Ribble Valley Borough Council
Housing & Development Control

Application no: **3/2020/0911**

Address: **Shackletons Garden Centre Ltd Clitheroe Road Chatburn BB7 4JY**

Proposal: **Proposed two-storey extension to rear and re-modelling of home and garden centre, including additional indoor and outdoor retail space and increased cafe area and play area.**

proposed car park layout 1/2

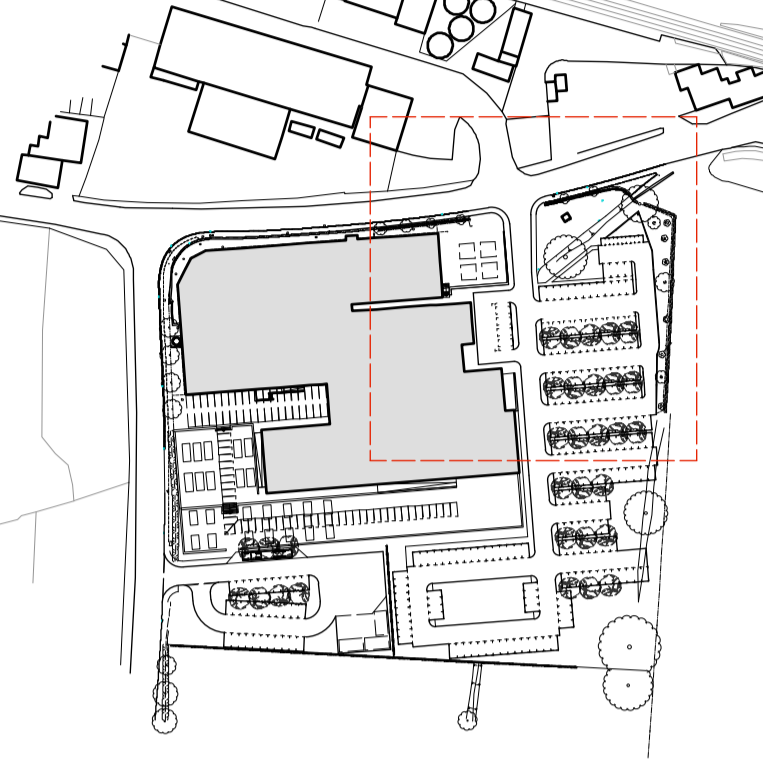
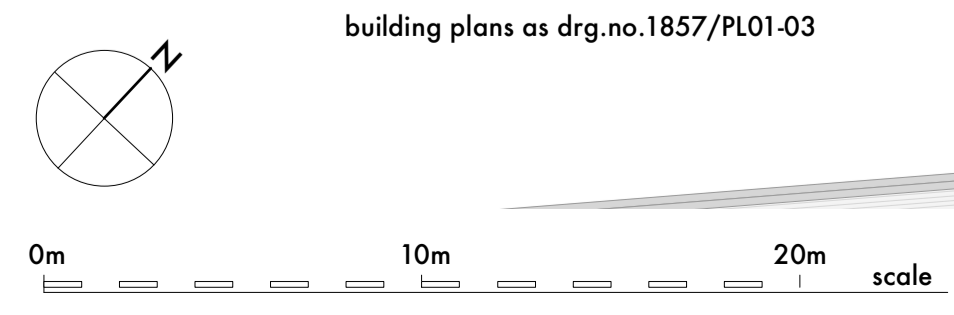
The LHA have reviewed Stanton Andrews drawing number PL.01 Rev D titled "Proposed Site Plan," and understands that the existing car park will be extended from 155 car parking spaces to 241 spaces, following the extension to the site. An increase of 86 car parking spaces.

While the quantity of parking spaces at the site does not comply with the parking standards as found in the Joint Lancashire Structure Plan, which requires an extension to an existing Class E site with the internal floorspace of 2308sqm to provide an additional 110 spaces the LHA will accept the shortfall. This is because the LHA in the previous highway comments dated 11th December 2020, previously accepted the same shortfall in car parking spaces at the site. Therefore, it would be unreasonable to request that that the site provides more spaces at the site.

Not only this but the extension to the site is unlikely to heavily intensive the traffic already generated to the site, as demonstrated in the Trip Generation section of the comments and vehicles are unlikely to inappropriately park on Clitheroe Road which experiences high traffic flows on a day-to-day basis, should the sites car park be full to capacity. Therefore, the LHA will accept the shortfall in parking at the site.

The LHA are also aware the site will provide 13 disabled spaces, 10 motorcycle bays, 4 electric vehicle charging bays and 36 cycle spaces, as stated in the Planning Statement. This complies with the LHAs guidance.

roof and site plan

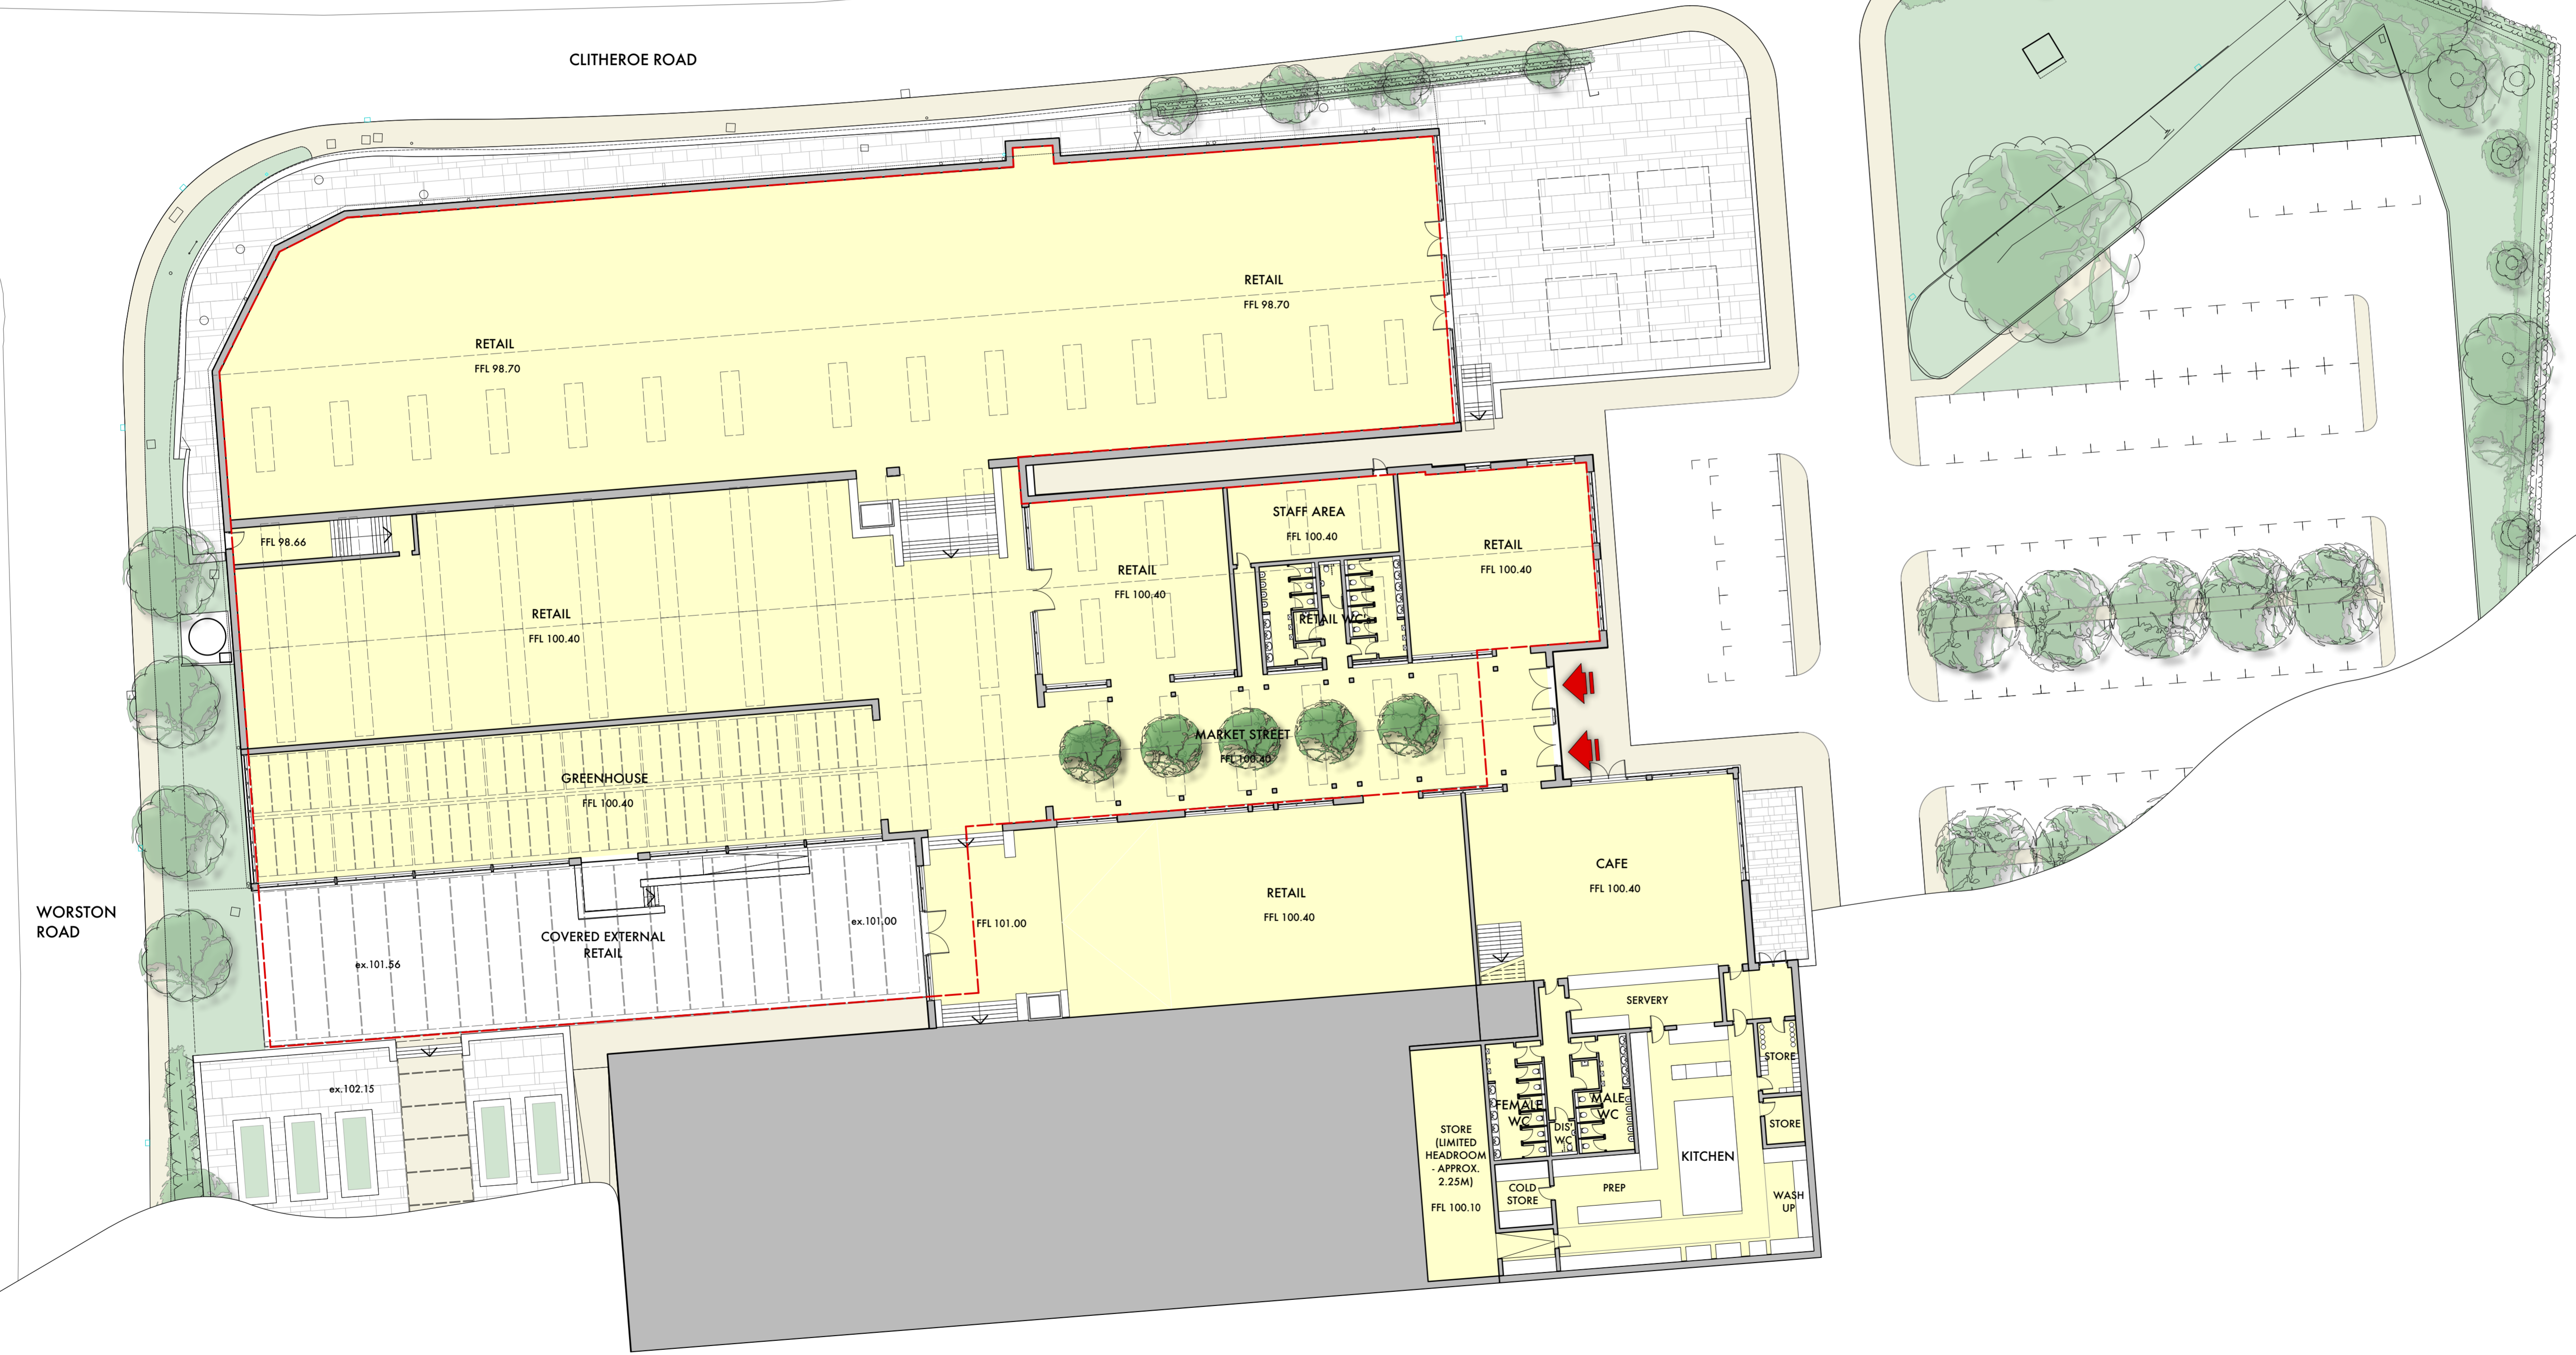
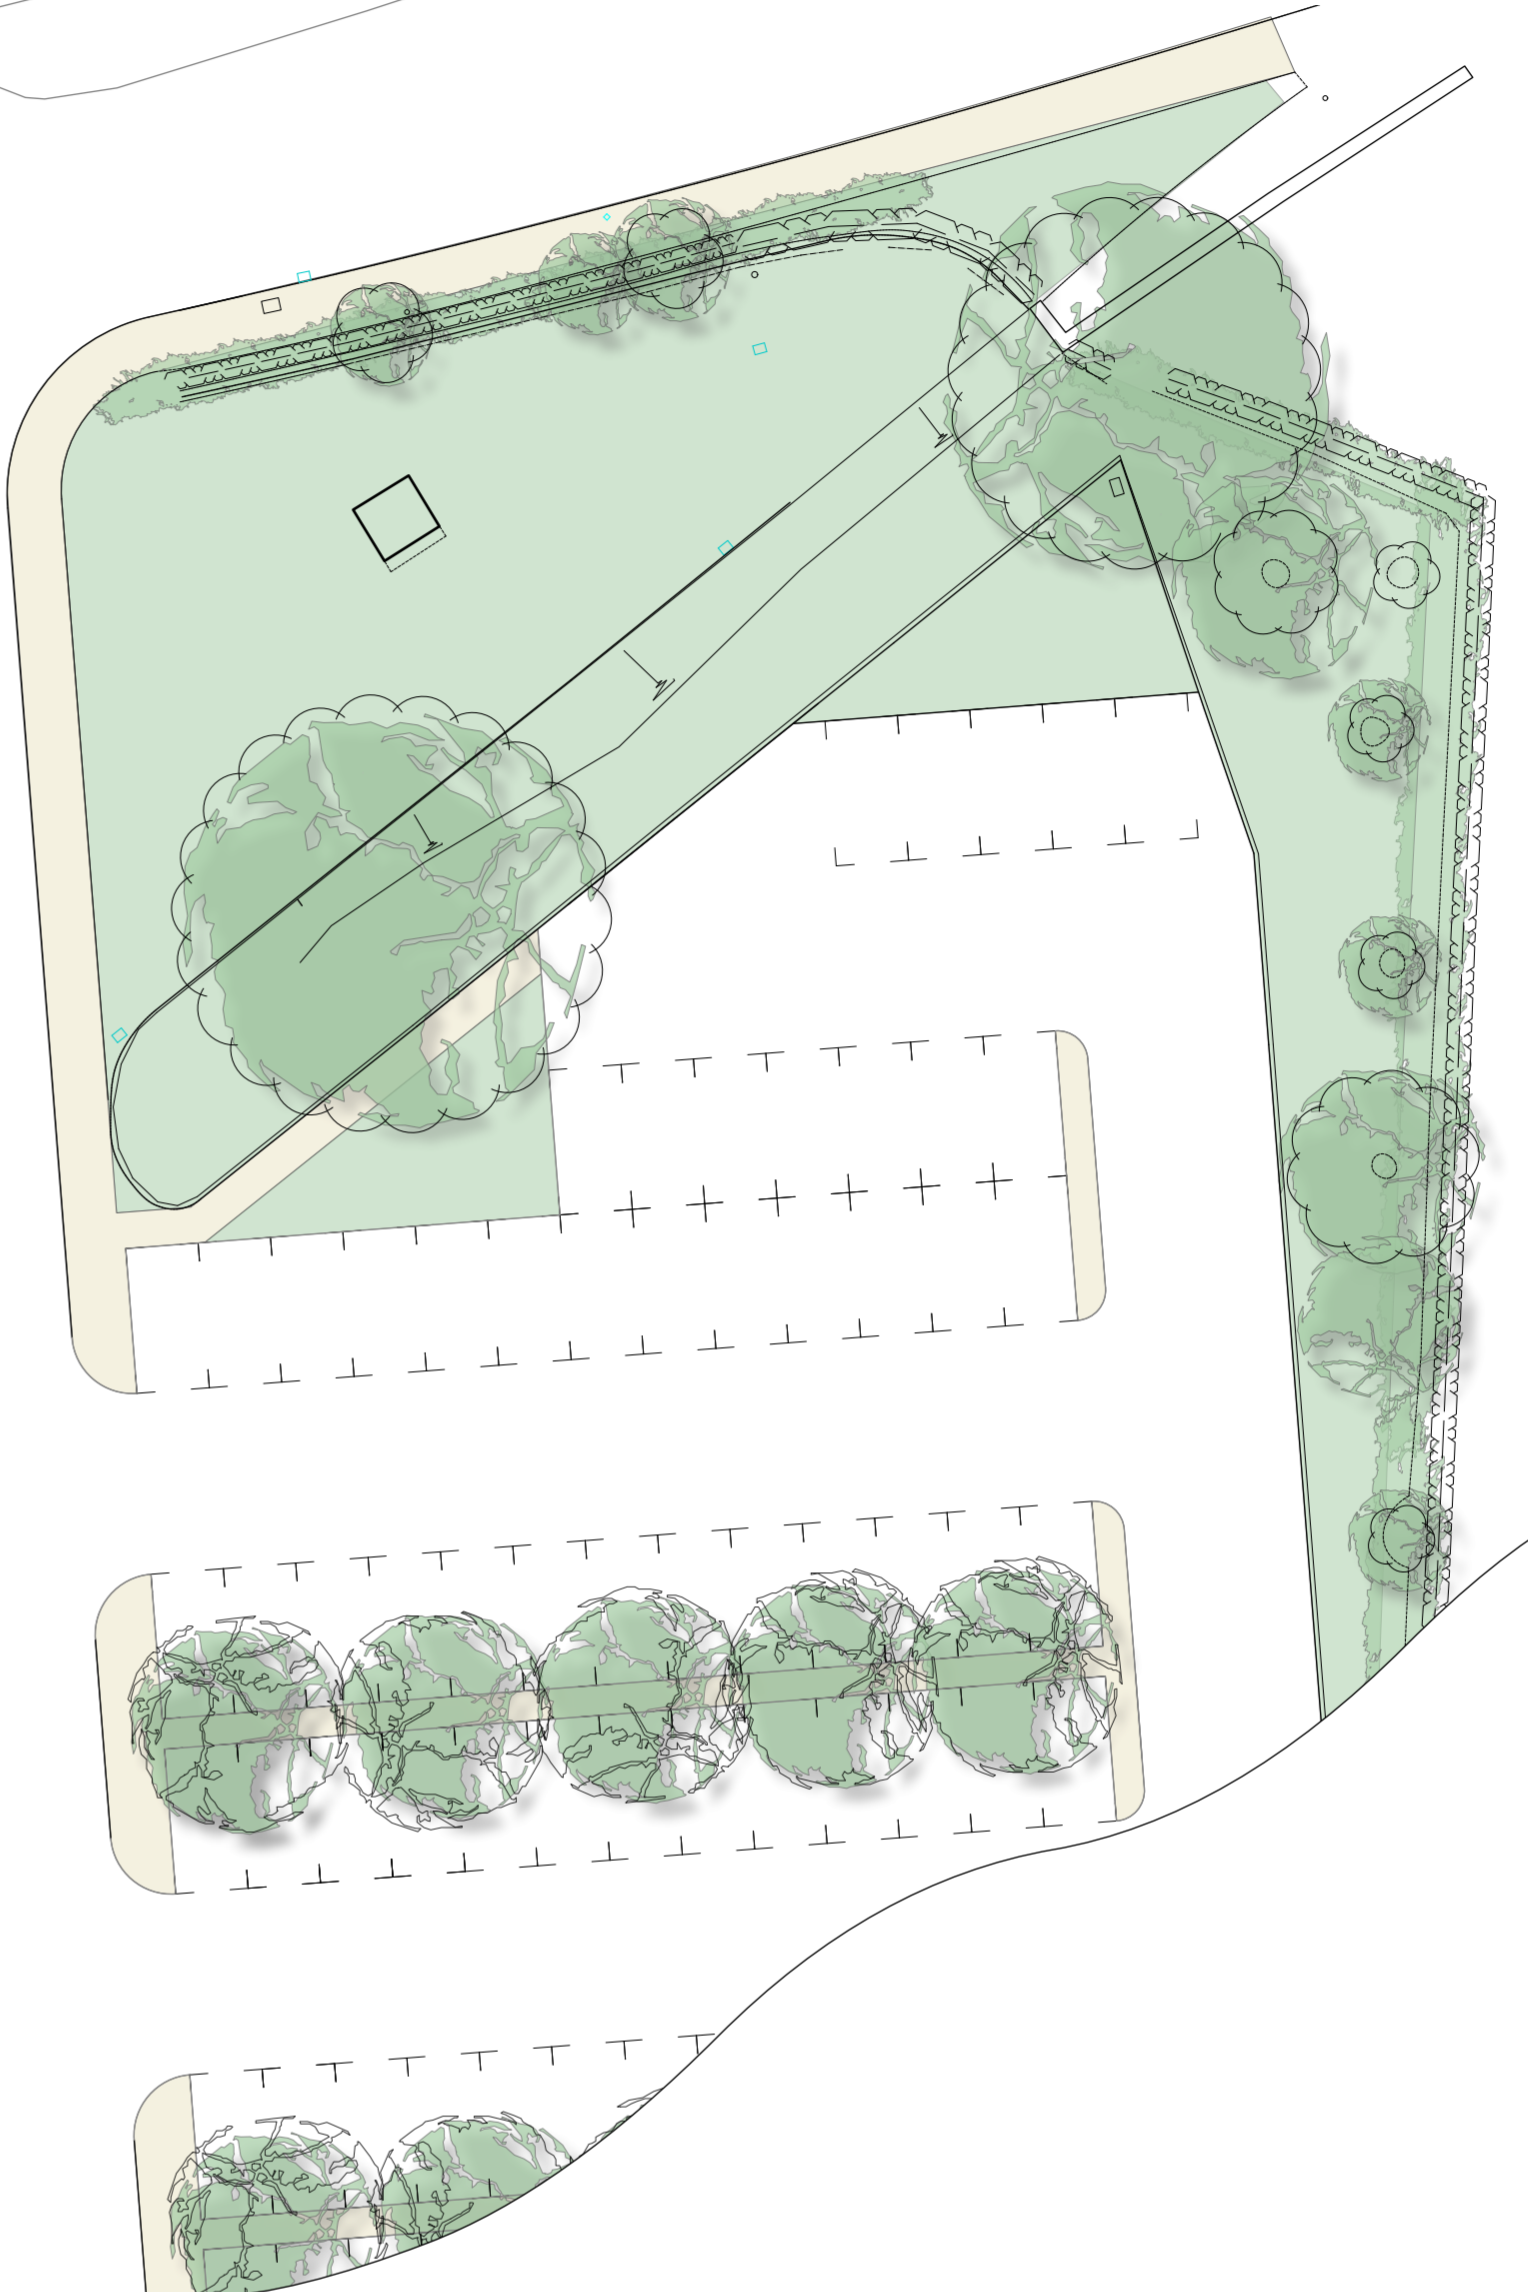
The LHA have also reviewed the visibility splays shown at the proposed access off Clitheroe Road and understands that the site can provide visibility splays of 2.4m x 43m in both directions.

However, the visibility splays shown on the drawing do not comply with the LHAs guidance for a 40mph road. Instead, the LHA require minimum visibility splays of 2.4m x 65m to be provided at the site to comply with the LHAs guidance found in Lancashire's "Creating Civilised Streets" document.

The LHA remind the Applicant that should the proposed access not be able to provide the minimum visibility splays for a 40mph road, the LHA require a speed survey to be undertaken at the proposed site access, demonstrating the 85th percentile speeds of traffic along Clitheroe Road. The speed survey should then be submitted along with a visibility splay drawing to the LHA.

Not only this but the LHA are concerned about the relocation of the proposed access. This is because the proposed access will create an informal crossroad junction along Clitheroe Road. A crossroads will occur in this location due to the proposed access overlooking an industrial access which serves Pendle Trading Estate. Therefore, the LHA advise that the proposed access is further relocated

along Clitheroe Road due to highway safety concerns associated with creating an informal crossroads.

The LHA also have concerns associated with the site entrance/exit having 3 lanes as shown on the drawing. This is because the width of the carriageway which is approximately 6.2m wide, is extremely narrow to incorporate 3 lanes. Therefore, the LHA are concerned that due to the carriageway being narrow that conflicts could occur between vehicles manoeuvring into the correct lane.

Not only this but the LHA are concerned that vehicular visibility for vehicles using the left lane will be skewed when vehicles are using the right lane when exiting the site. This is because the vehicle in the right lane will be blocking the view which could cause conflicts to occur should vehicles in the left lane guess when the road is clear. This would be to the detriment of highway safety.

Therefore, the LHA advise that only two lanes are used at the site entrance/exit. This should be shown along with the relocation of the site access on a revised drawing.

As mentioned above, the secondary access at the site will also be relocated as shown on Stanton Andrews drawing number PL.01 Rev D titled "Proposed Site Plan," further along Worston Road.

While the LHA have reviewed the drawing and the access arrangements along with the visibility splays comply with the LHAs guidance, the LHA are concerned about large delivery vehicles using the access. This is because as shown on the swept path analysis drawing on the revised plan, the delivery vehicle exiting the site and turning right onto Worston Road, overlaps the grass verge and then the footway as it exits the site. The drawing also shows its extremely narrow for delivery vehicles to enter the site, with the swept path being extremely close to the footway. Therefore, the LHA require the access and the carriageway into the site to be widened which should be shown on a revised drawing. A revised swept path analysis drawing should also be submitted.

However, the LHA would require secure and undercover cycle facilities to be provided at the secondary access located off Worston Road so that staff members have access to cycle spaces as well. This should be shown on a revised plan.
